3 March 2016
5578

Dear Ms Harras,
RE: 1 Lawson Square Redfern 2016

We refer to your email of 29 February 2016 wherein you request further consideration and a response to the review by the Department of Planning and Environment to the Section 96 drawings (Issue E) lodged with the department on the 26 February 2016. You have requested that we provide a response to concerns raised by the Department of Planning and Environment.

Department of Planning and Environment comments prepared by Natasha Harras

DRAWING No.
SK – 02

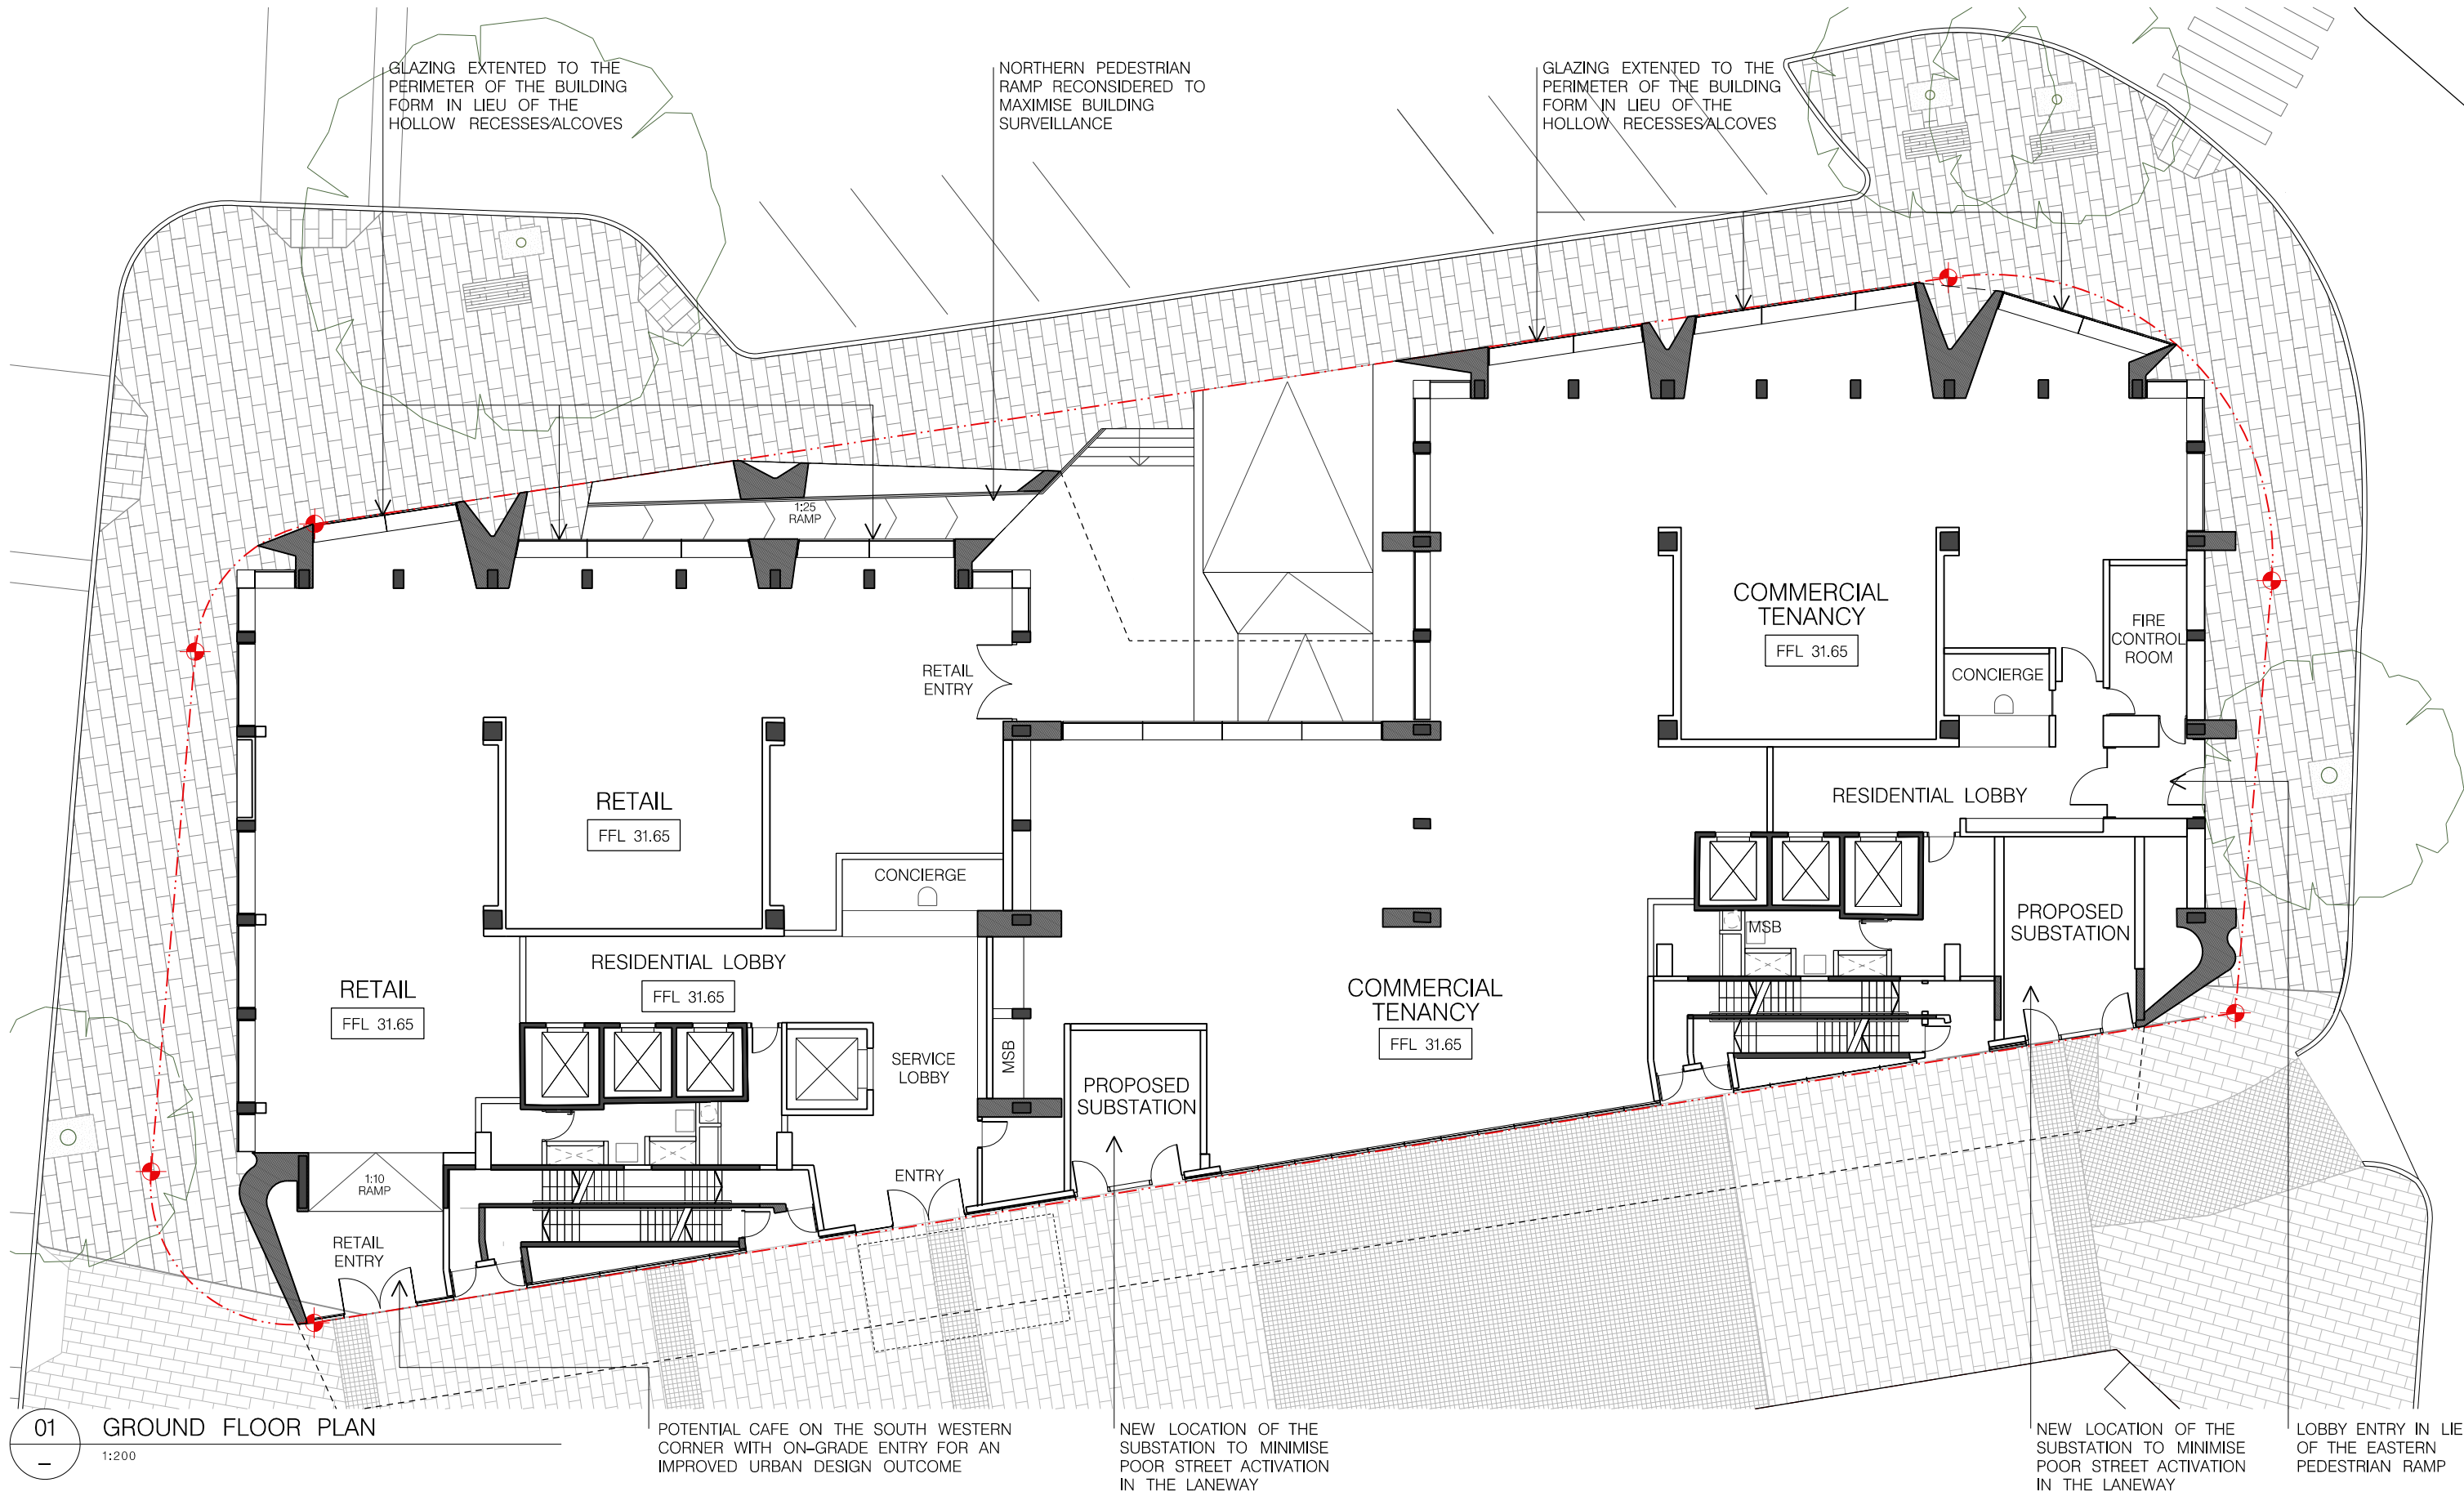
3. *Could you identify how the south facing units have increased in size? We can't identify where the change is by viewing the plans*

Response: The walls surrounding the apartment were designed to be 250mm structural concrete walls at lodgement. We have worked with the structural engineer to remove these structural walls; the walls are now a 135mm wall system. This change provided an additional 2sqm to the area of these apartments.

02 GROUND FLOOR PLAN

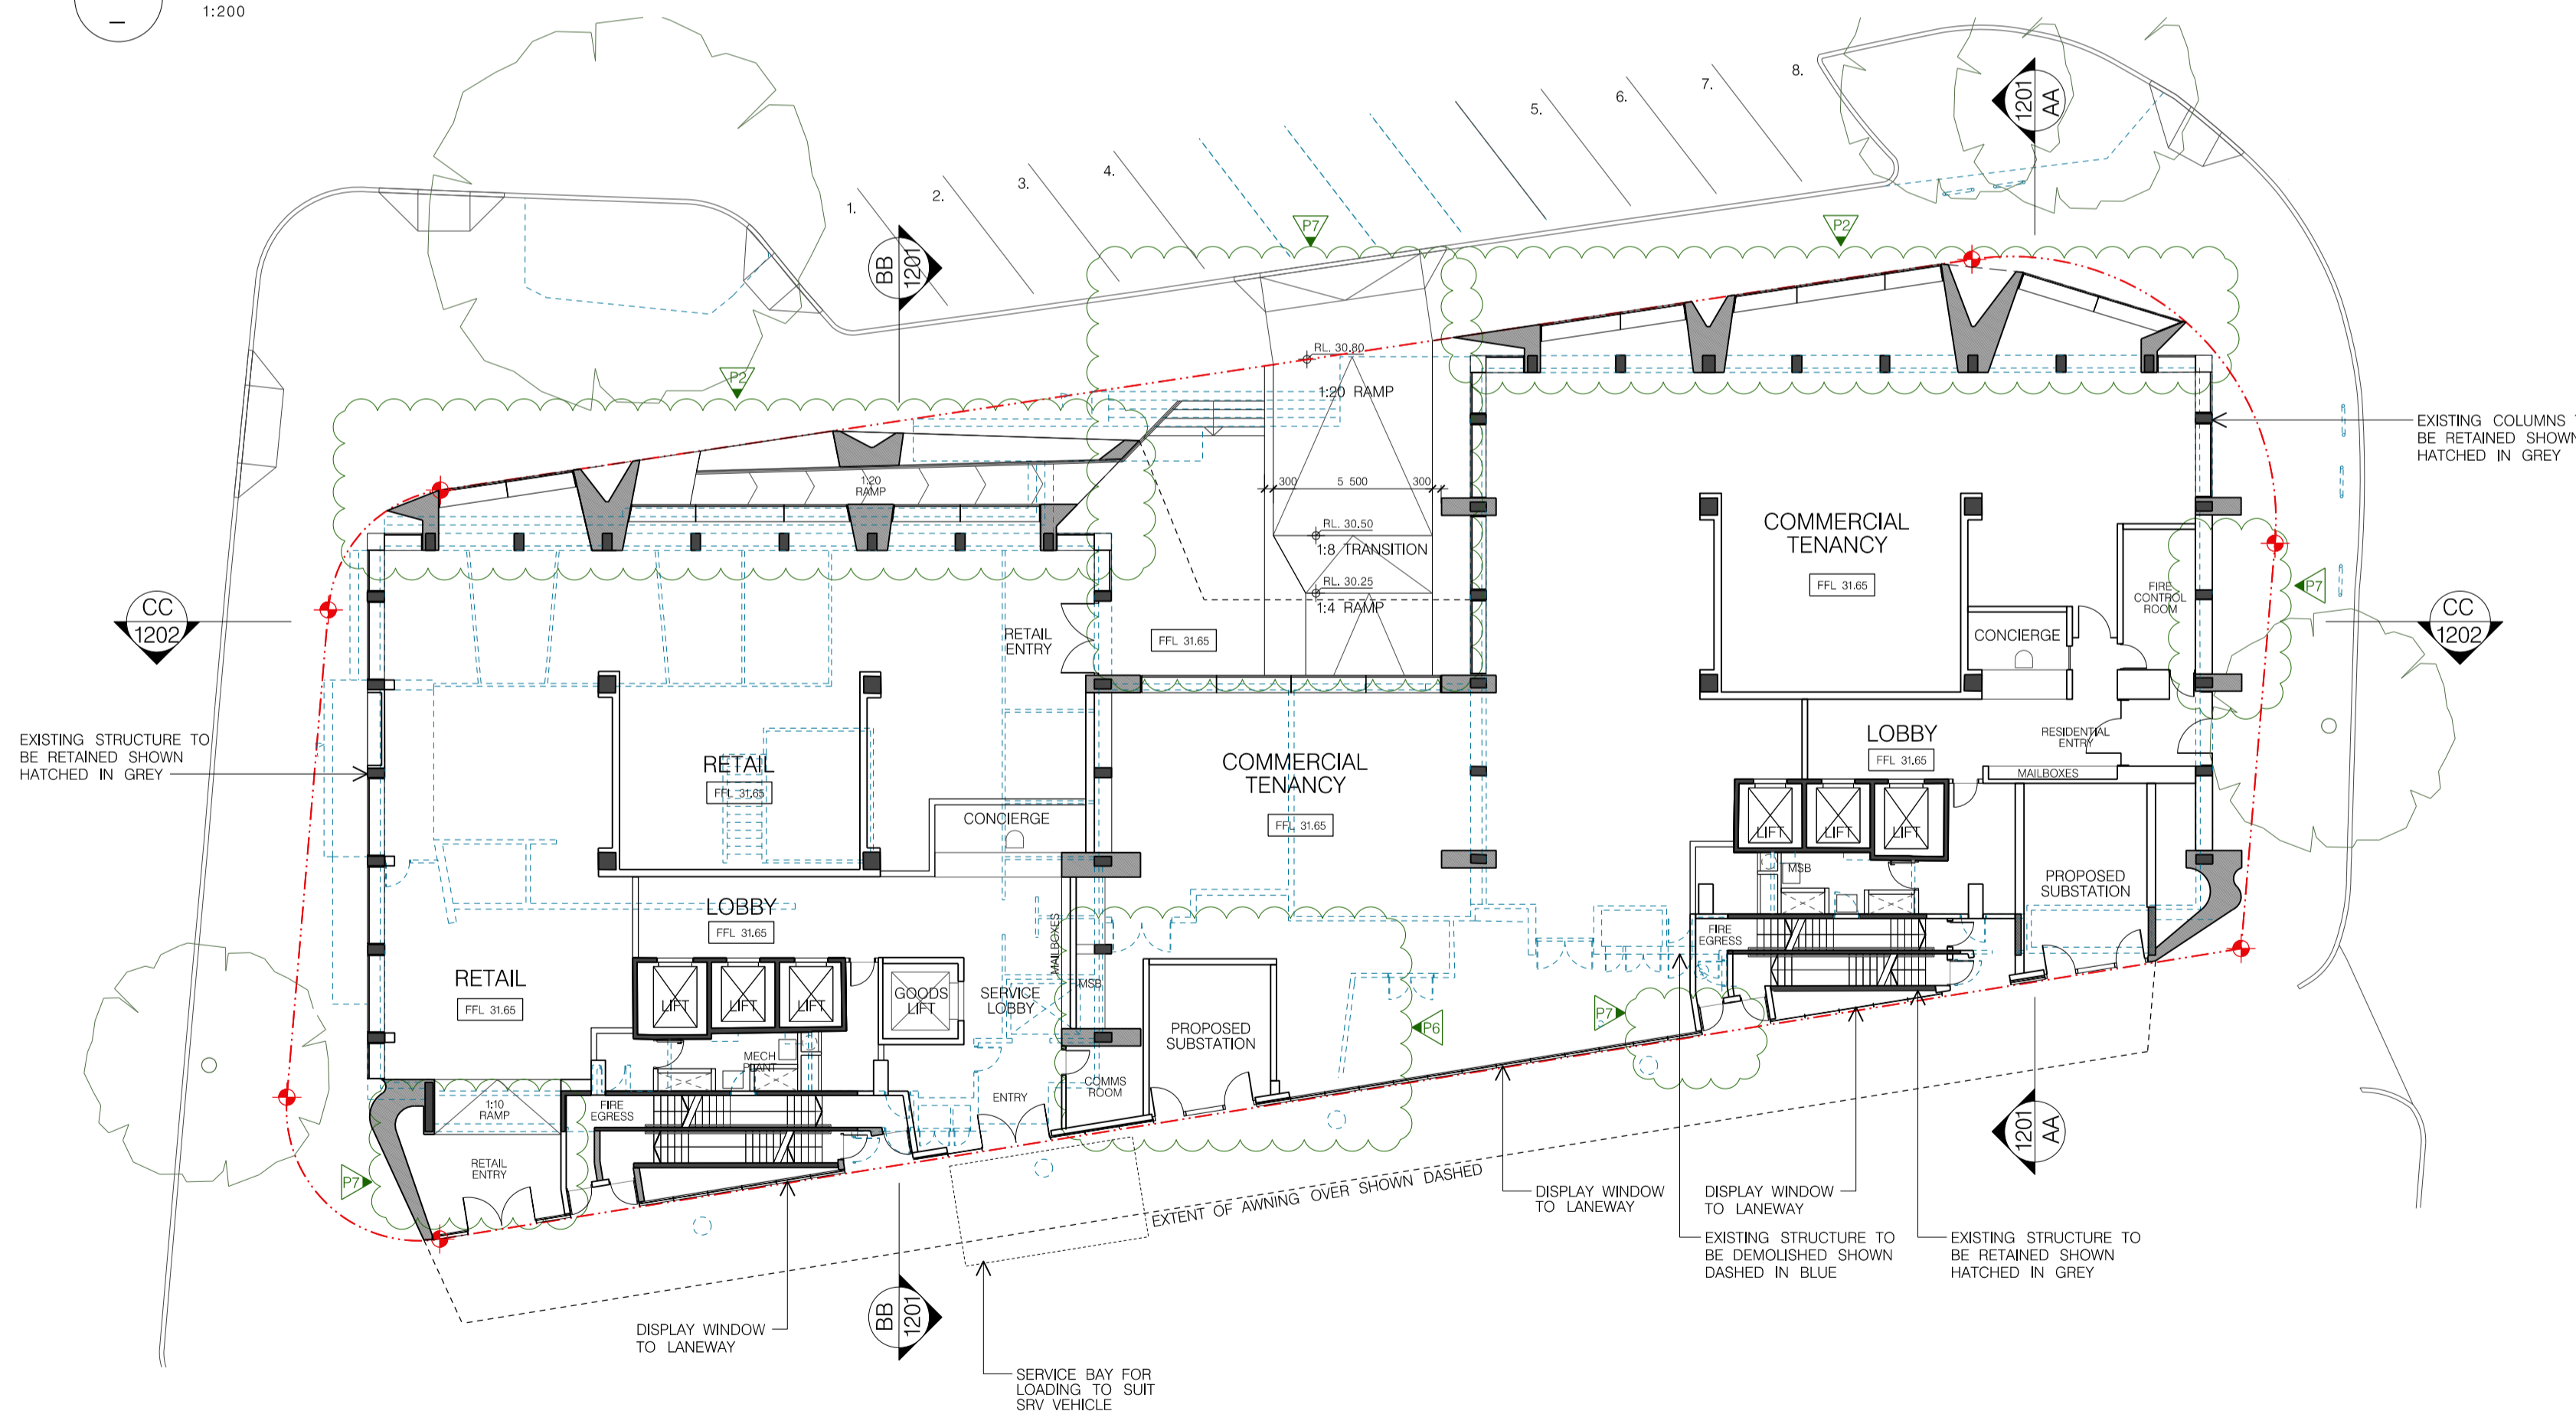
- 2. The Redfern Street Laneway is a key frontage and as approved, the level of activation is already very low. It was only accepted due to location of the existing services which the proponent advised precluded any further activation. The Department is not supportive of any further reduction in the level of activation of the laneway compared to the approved scheme. Ideally the substations should be internal to the site as approved, but if that is not possible, it may be necessary to consider locating them sympathetically on another frontage.*

Response: The current approval was based on high level advice received from the electrical consultant at the time indicating that the existing internally located substation had the capacity to power both towers subject to Ausgrid confirmation. Ausgrid have since confirmed that the existing substation will not be suitable to power the proposed development. Note the following reasons that led to the substations being located where they are currently proposed:

- 1. Internally located substations no longer comply with Ausgrid's current standards as they are now required to have access to natural ventilation on the façade.*
- 2. Two substations are required since the construction of the towers will be staged; the staging of the towers is required since tower 2 will need to be completed first in order for NSW police to move from tower 1 into tower 2.*

3. Ausgrid requires substations to be no more than 190mm above the adjacent footpath. This precludes them being located on the north façade, western façade and the eastern façade due to the elevated height of the existing ground floor slab.
4. In previous comments provided the department and the city of Sydney, it was requested that we provide on-grade entry to the proposed café on the south west corner and remove entry ramps where possible to improve street activation.
5. Ausgrid's current standards require that substations cannot be located in close proximity to windows/ entry points and ventilation points.

The location of the proposed substations balances the significant urban design/ street activation concerns with Ausgrid's substation design requirements. We share the concerns raised by the department with regard to the street activation of Redfern Street Laneway, however we believe that the proposed laneway façade design is the best possible outcome considering the constraints discussed above.
